CITY OF ALBUQUERQUE

**Re: Office Building Shell
2442 Louisiana Blvd. NE
30-Day Temporary Certificate of Occupancy
Transportation Development Final Inspection**
Architect's Stamp dated 05-27-22 (H19-D084A)
Certification dated 05-16-23

SHEET TITLE: SITE DEVELOPMENT PLAN

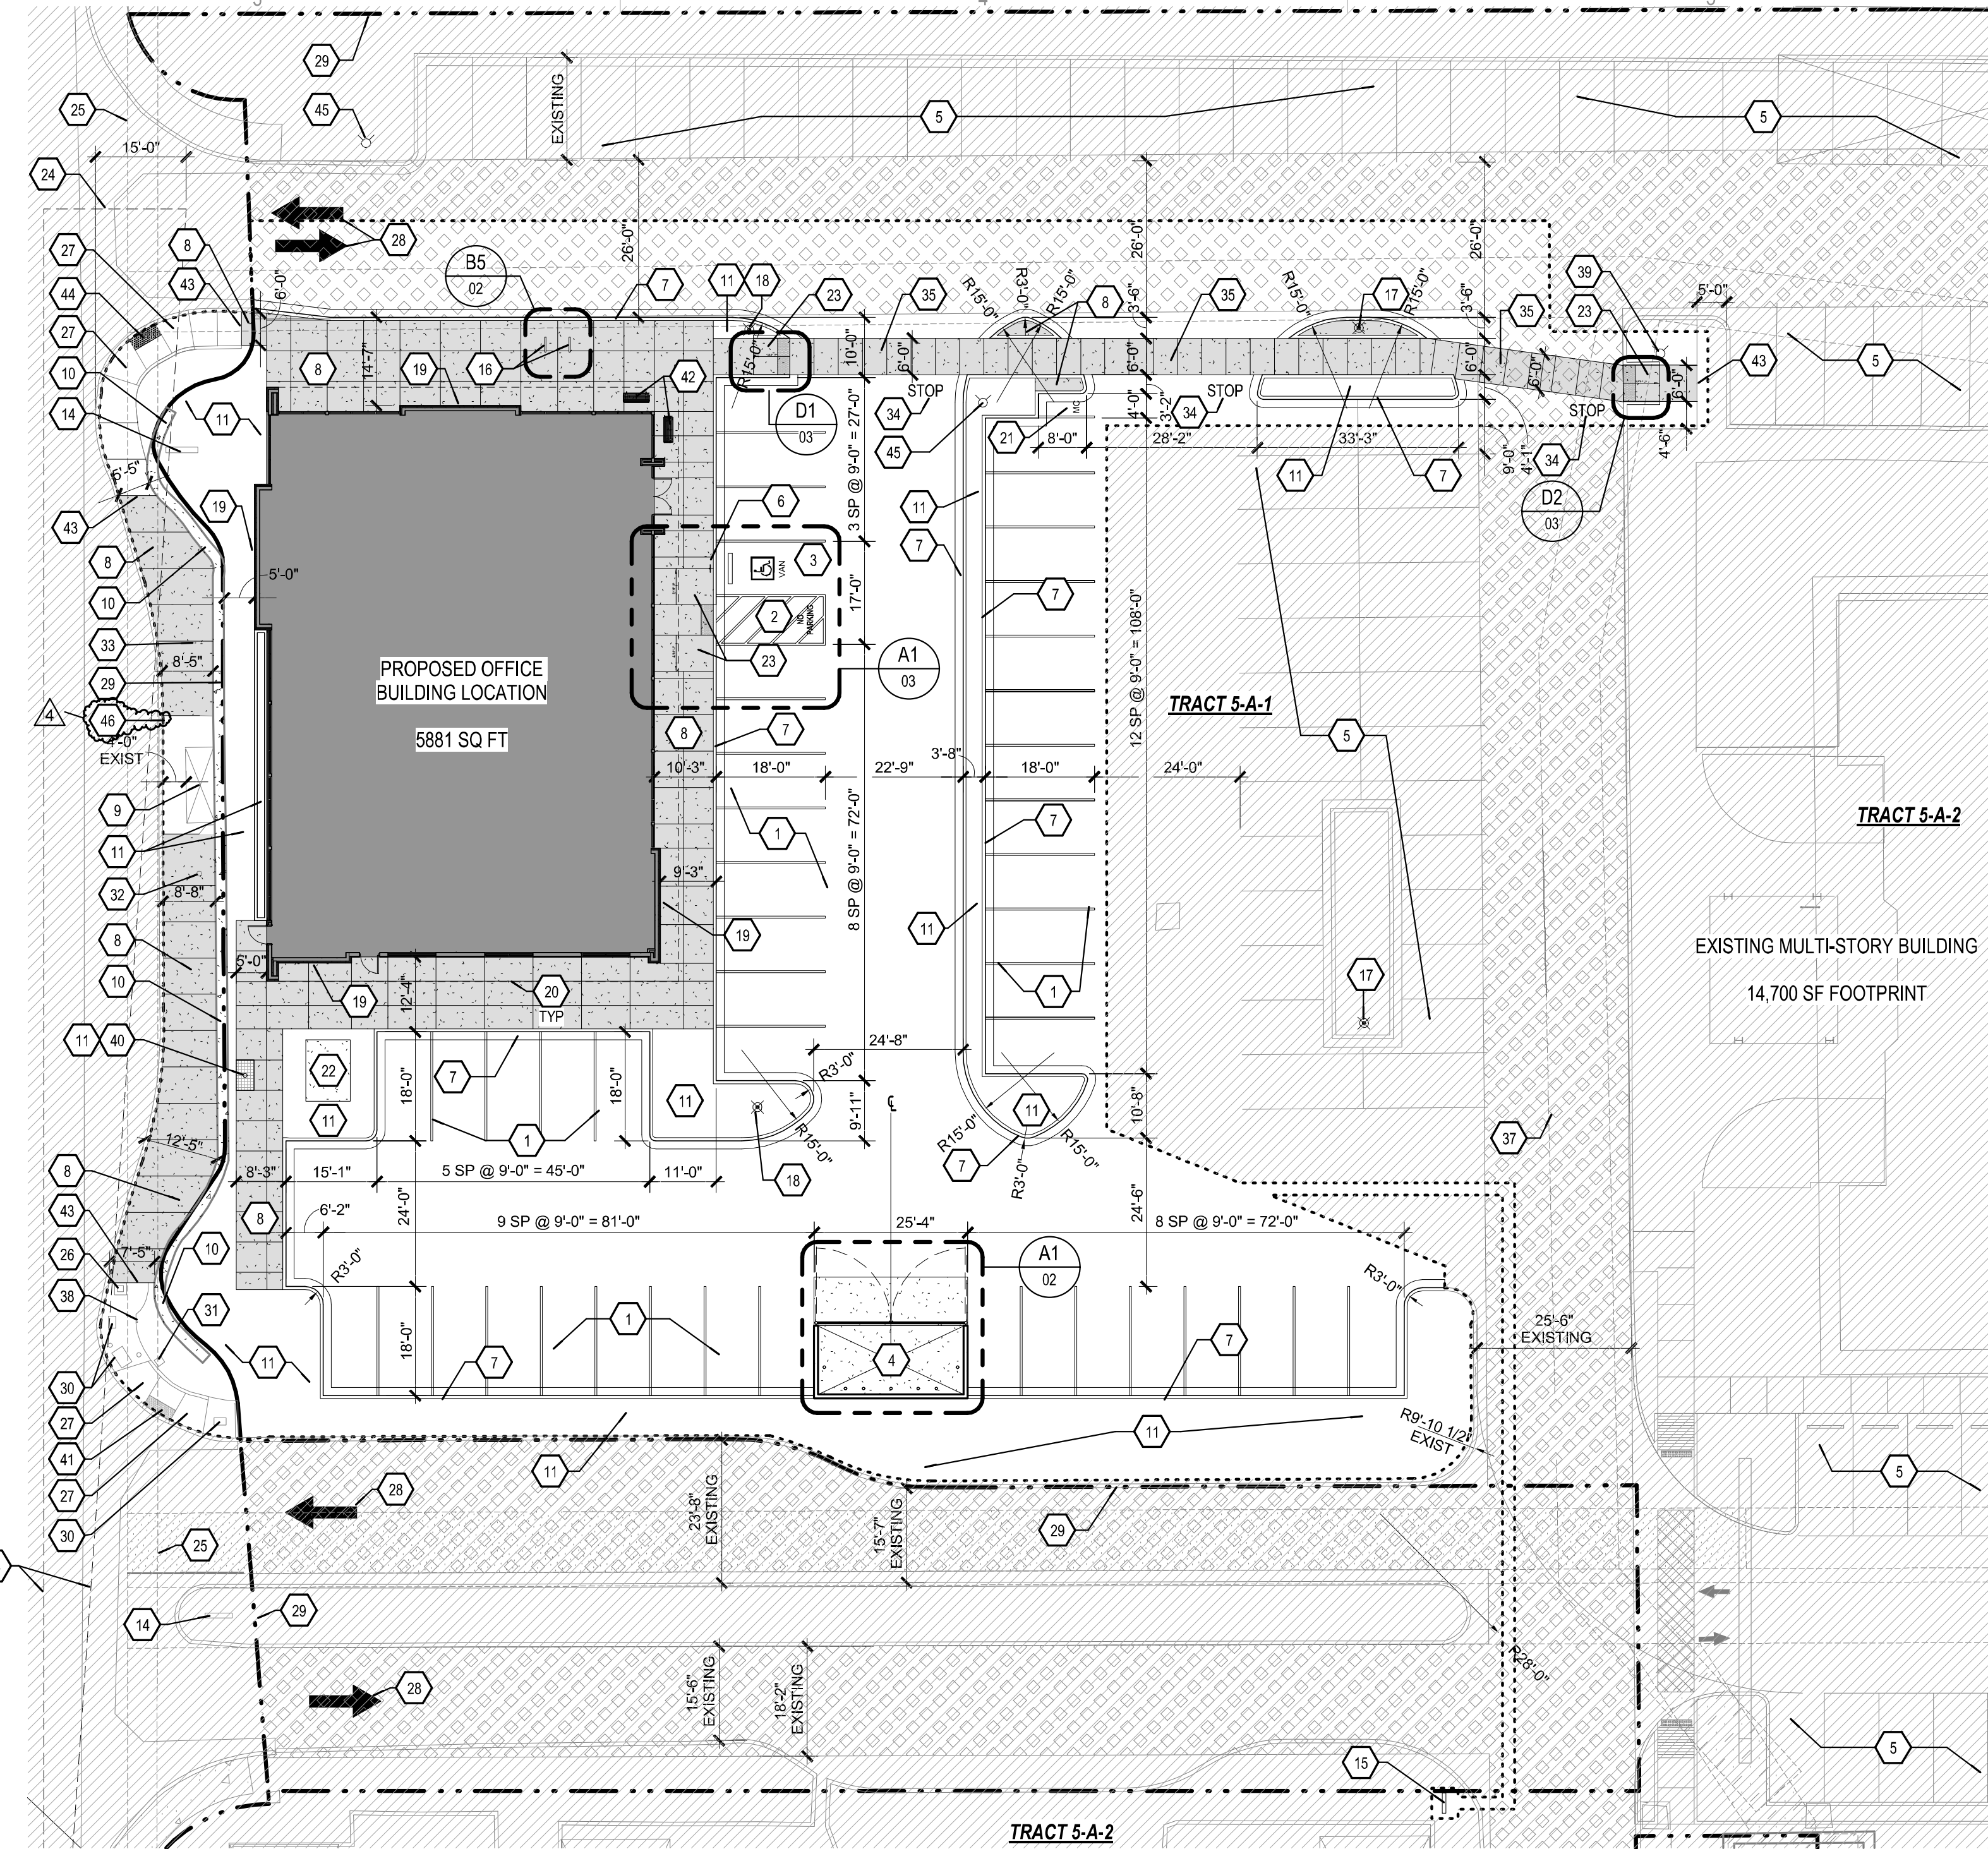
- Per approved plan keynote 44: Please install Truncated Domes on the ADA ramp at the public right of way.
- The pavement marking "MC" should be shown in the opposite direction for motorcycles entering the parking space.
